Our Ref: PR107832
Date: 13 November 2013

**RE: ADDENDUM TO SSD MOD 6 OF SSD 4949-2011 – 157-163 CLEVELAND STREET,
REDFERN – SECTION 94F CONTRIBUTIONS**

1 Key Plan - Ground Floor
 A02.101 1:200

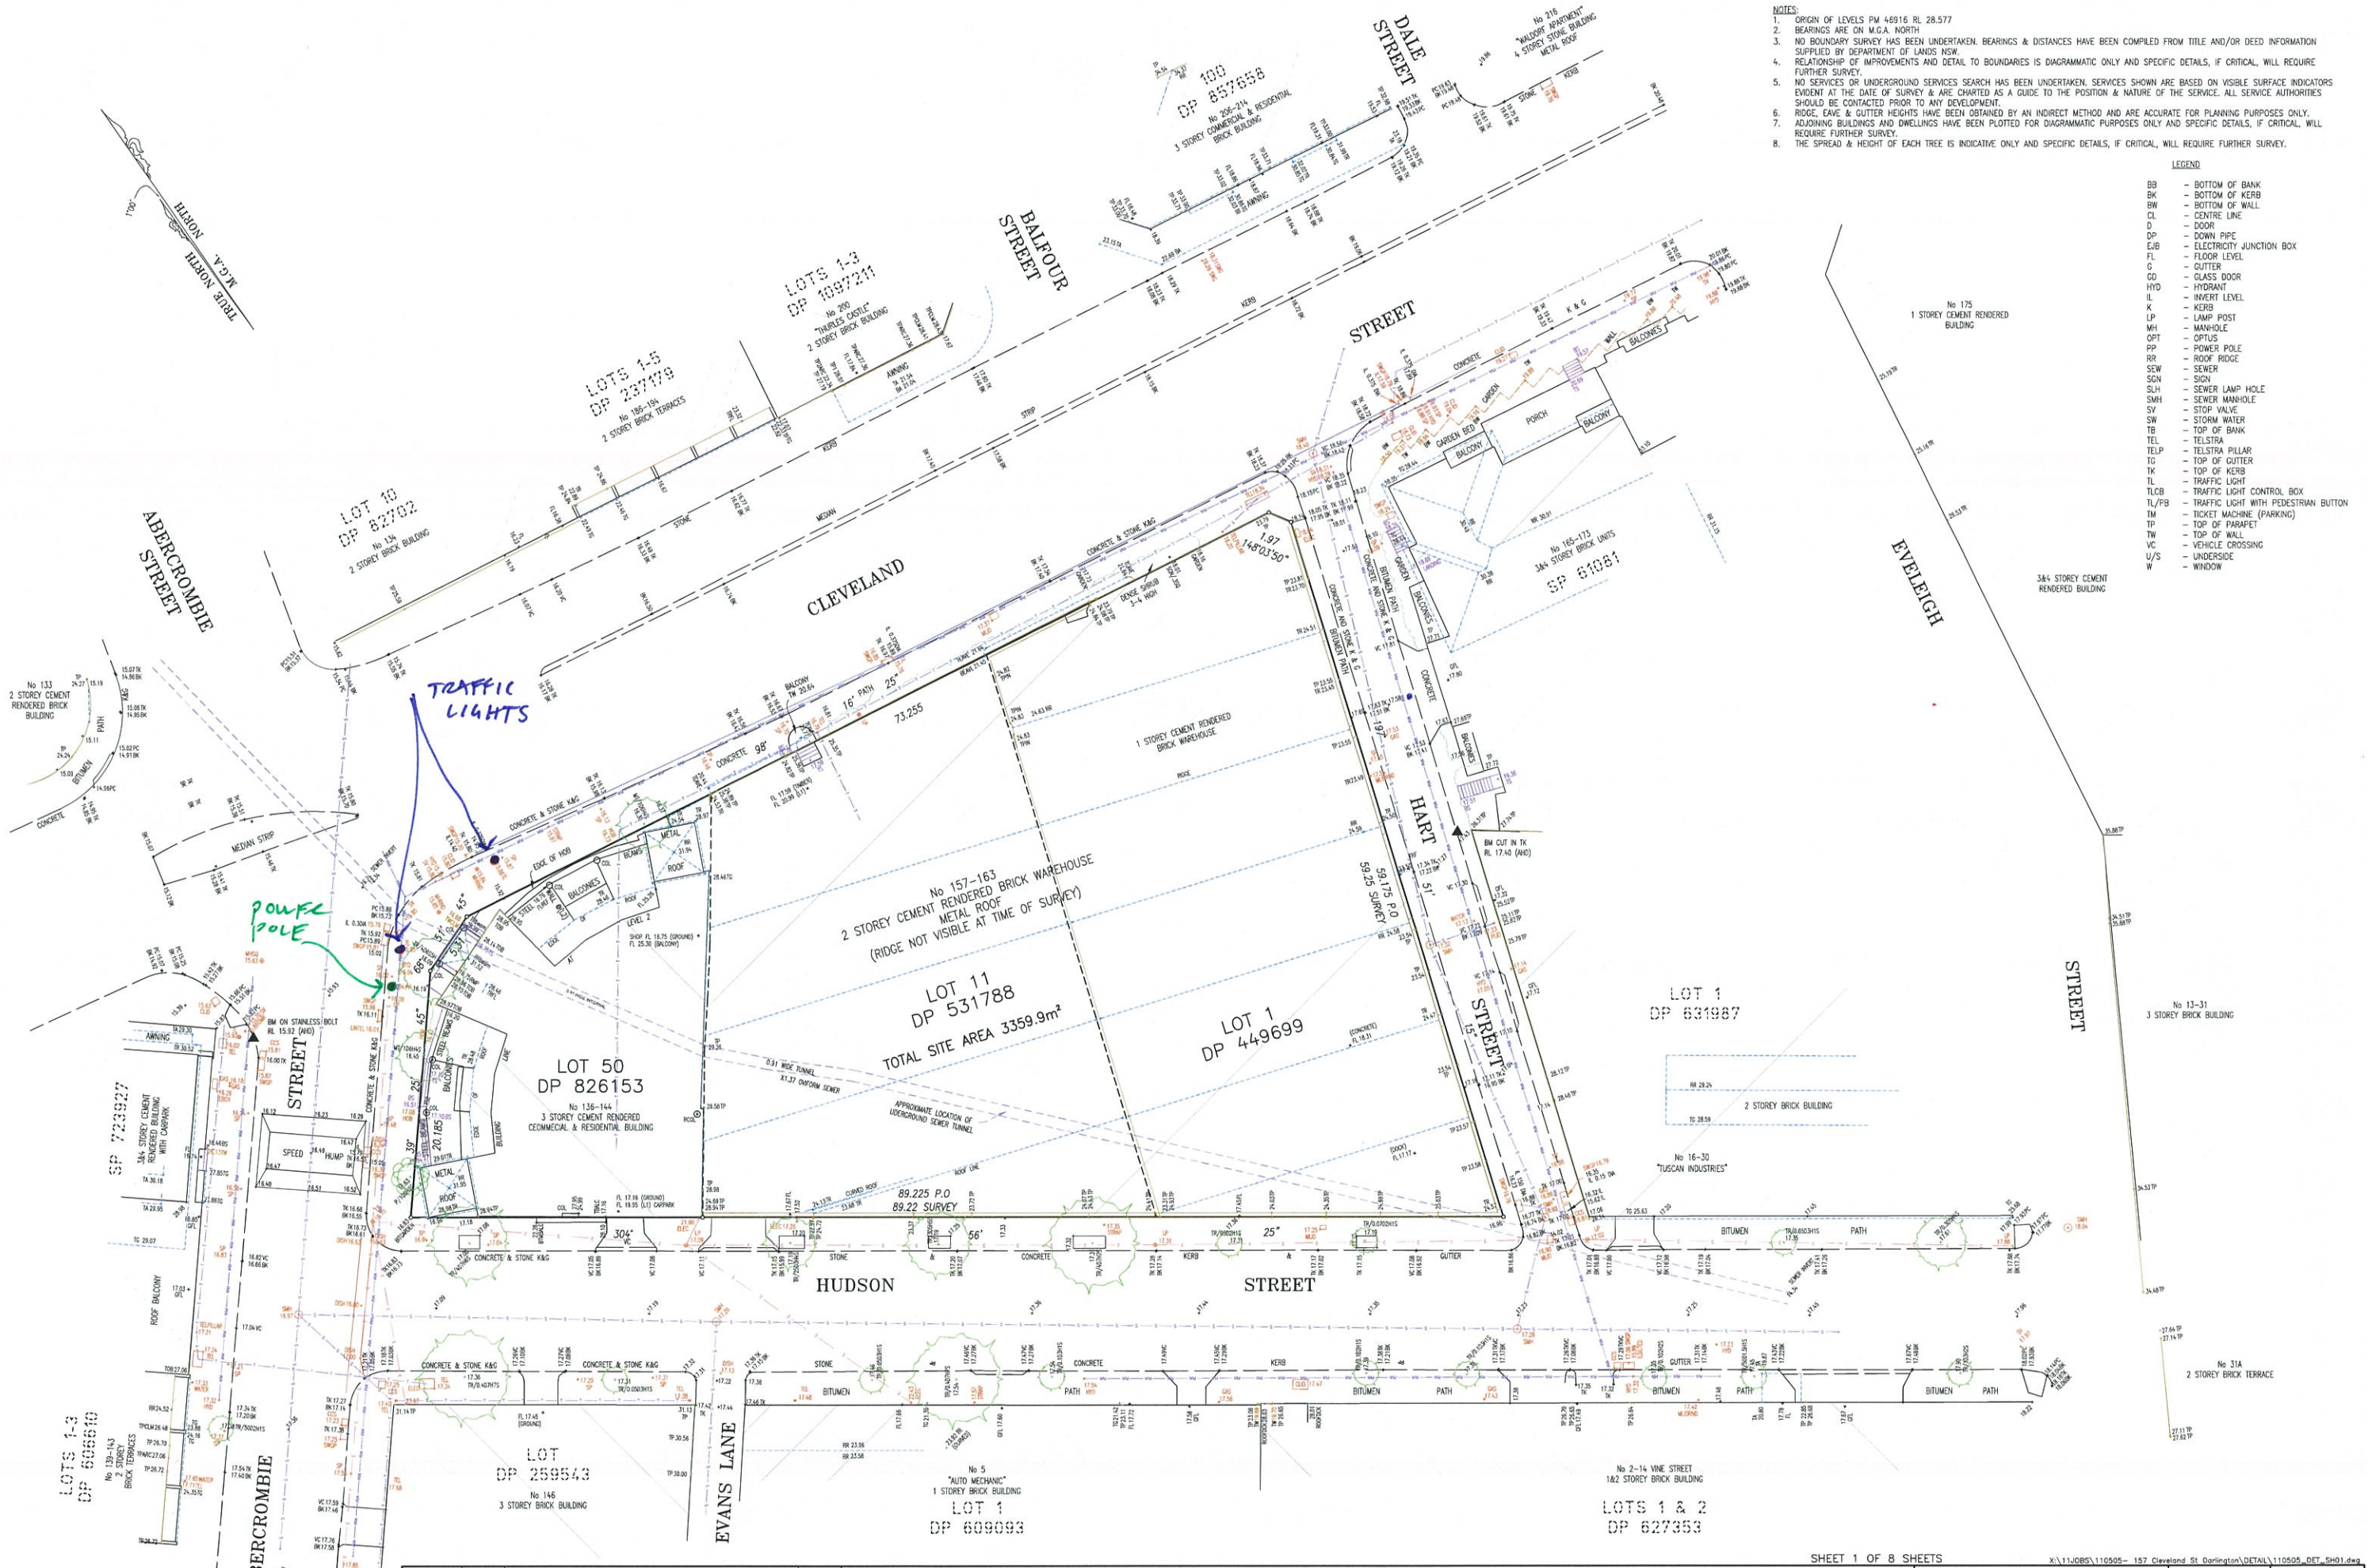
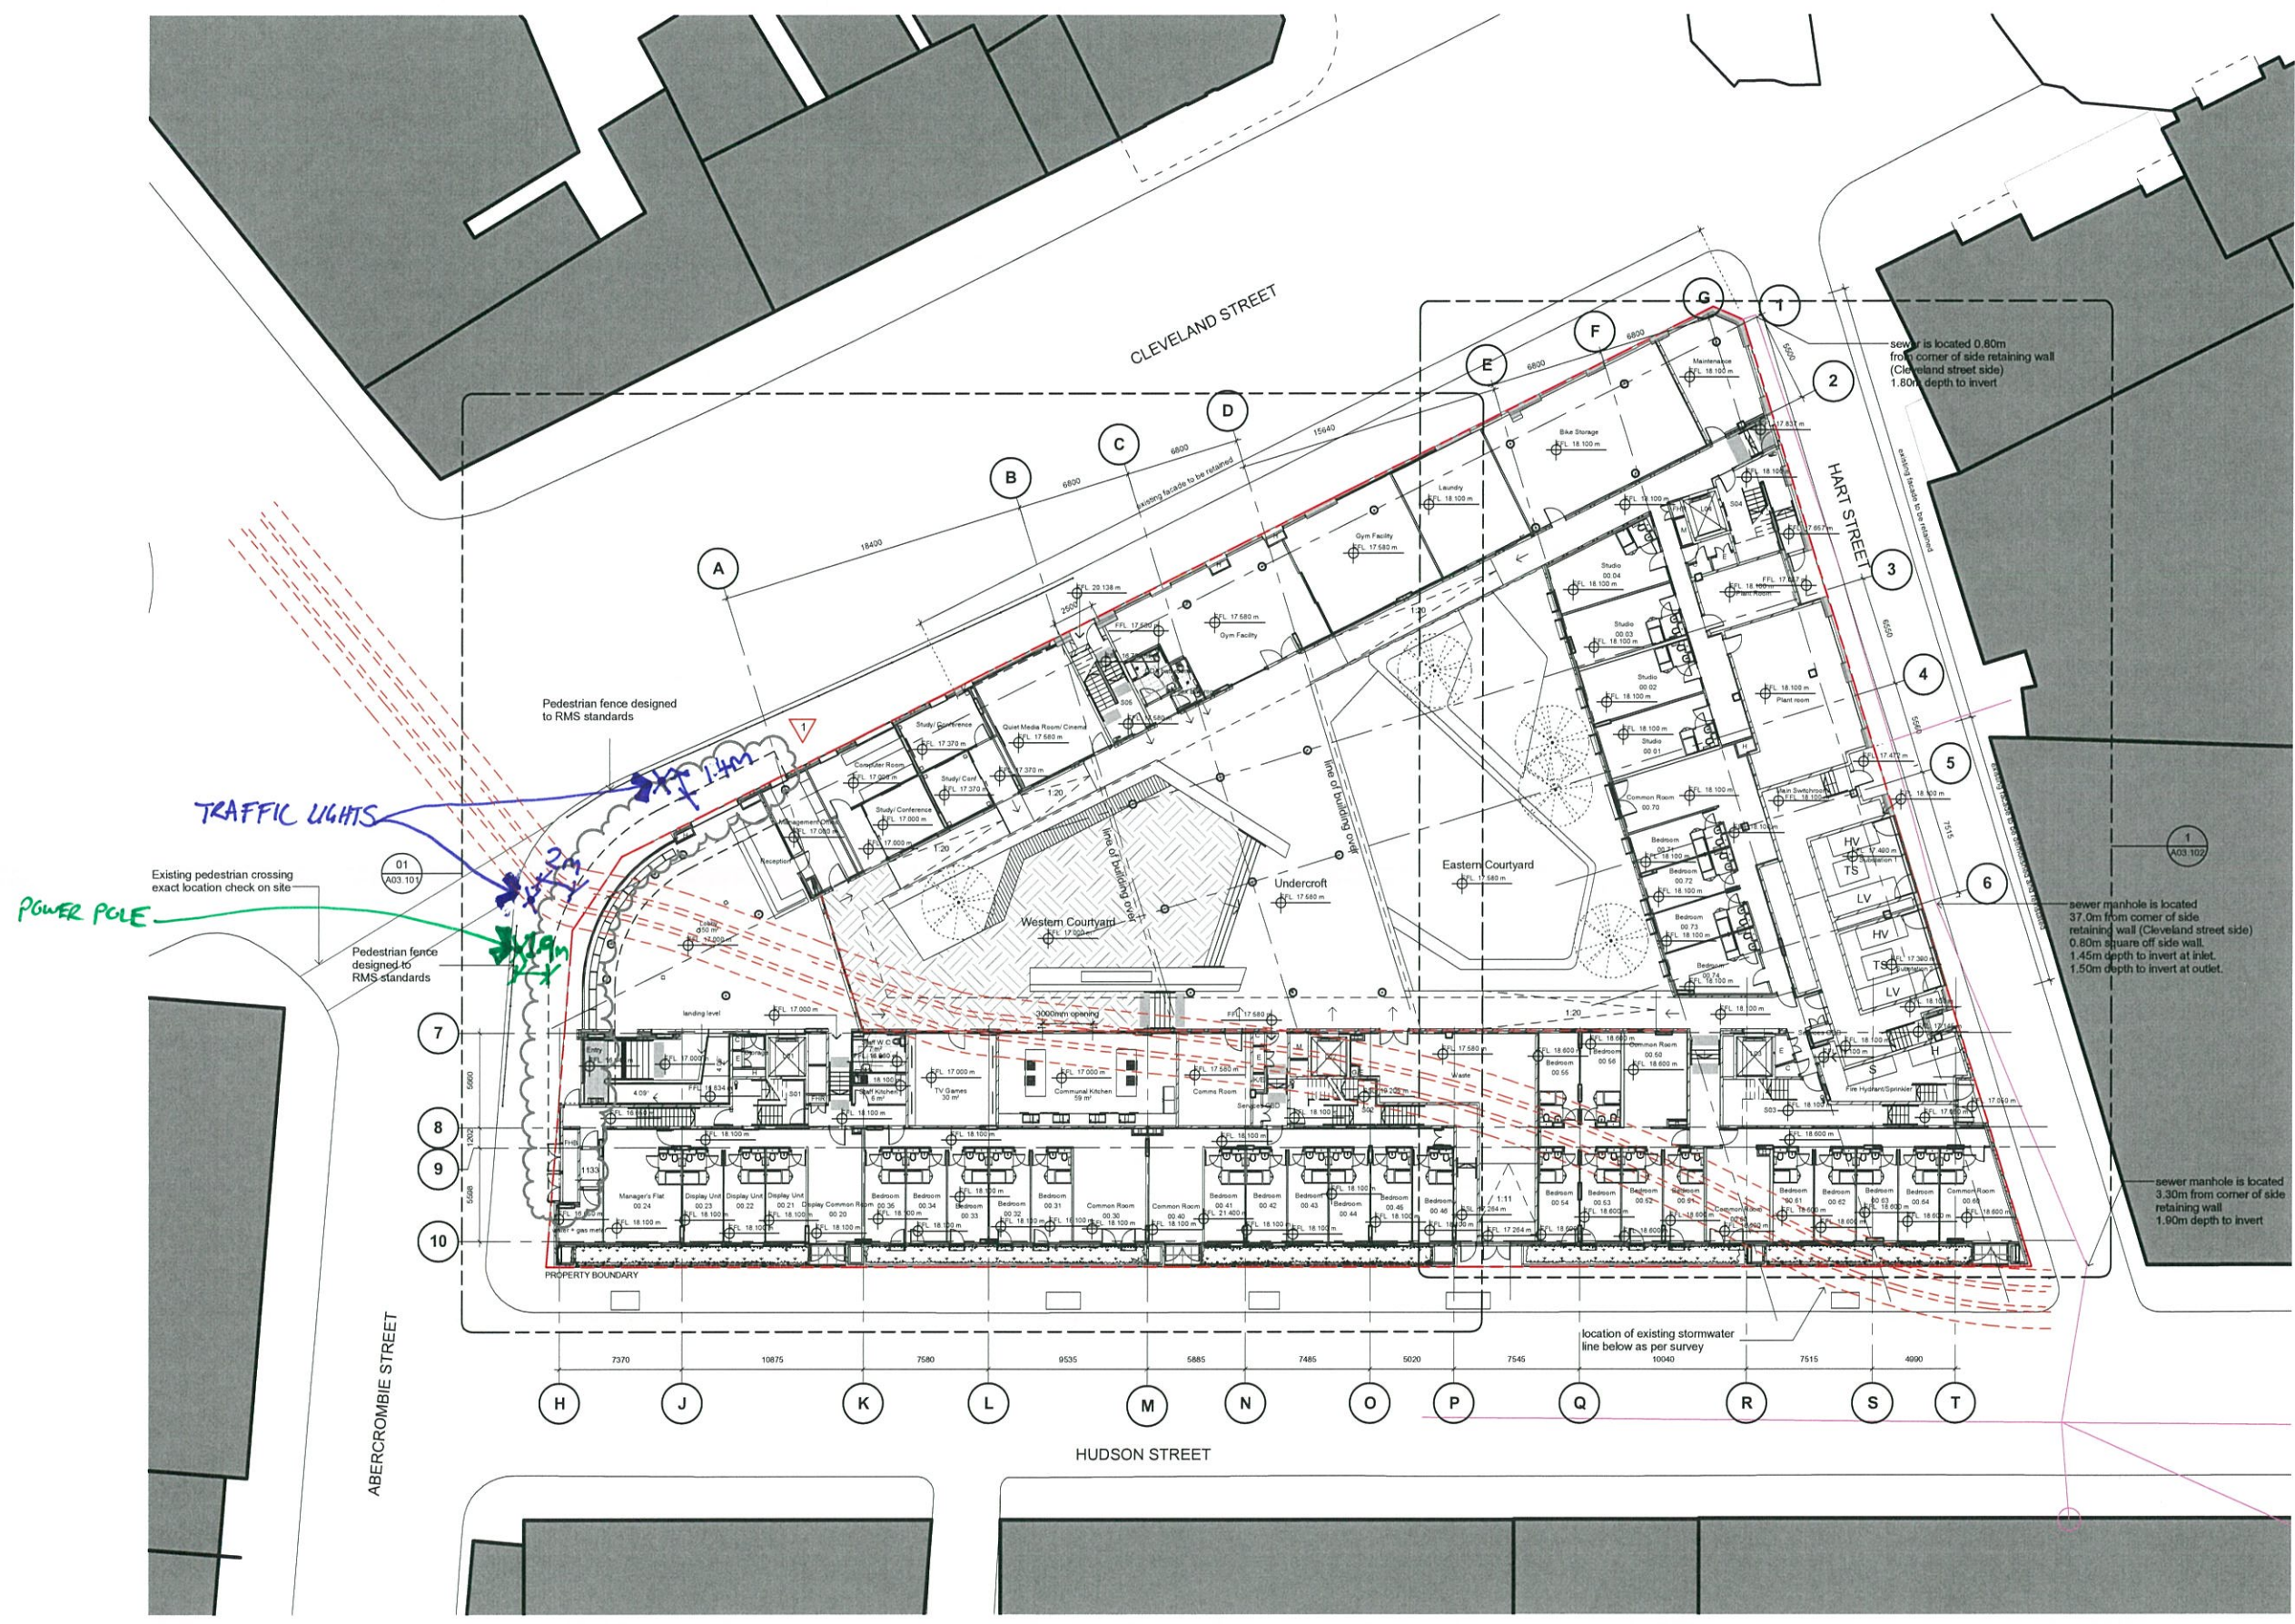
We provide this addendum in relation to the above application lodged to the Department of Planning and Infrastructure on 4 November 2013. We are seeking to amend our proposal to also incorporate the attached modification to the awning on the Cleveland and Abercrombie Street elevations.

An awning was approved under the original application. The awning was later modified to a shorter, wider awning under Modification 4. The proposed awning is a similar length to the originally approved awning and similar width to the awning approved under Modification 4.

The proposed awning is considered to be an improved design option and will maximise the area for weather protection. It achieves suitable separation distances from the neighbouring traffic lights and power poles as shown on the attached plans.
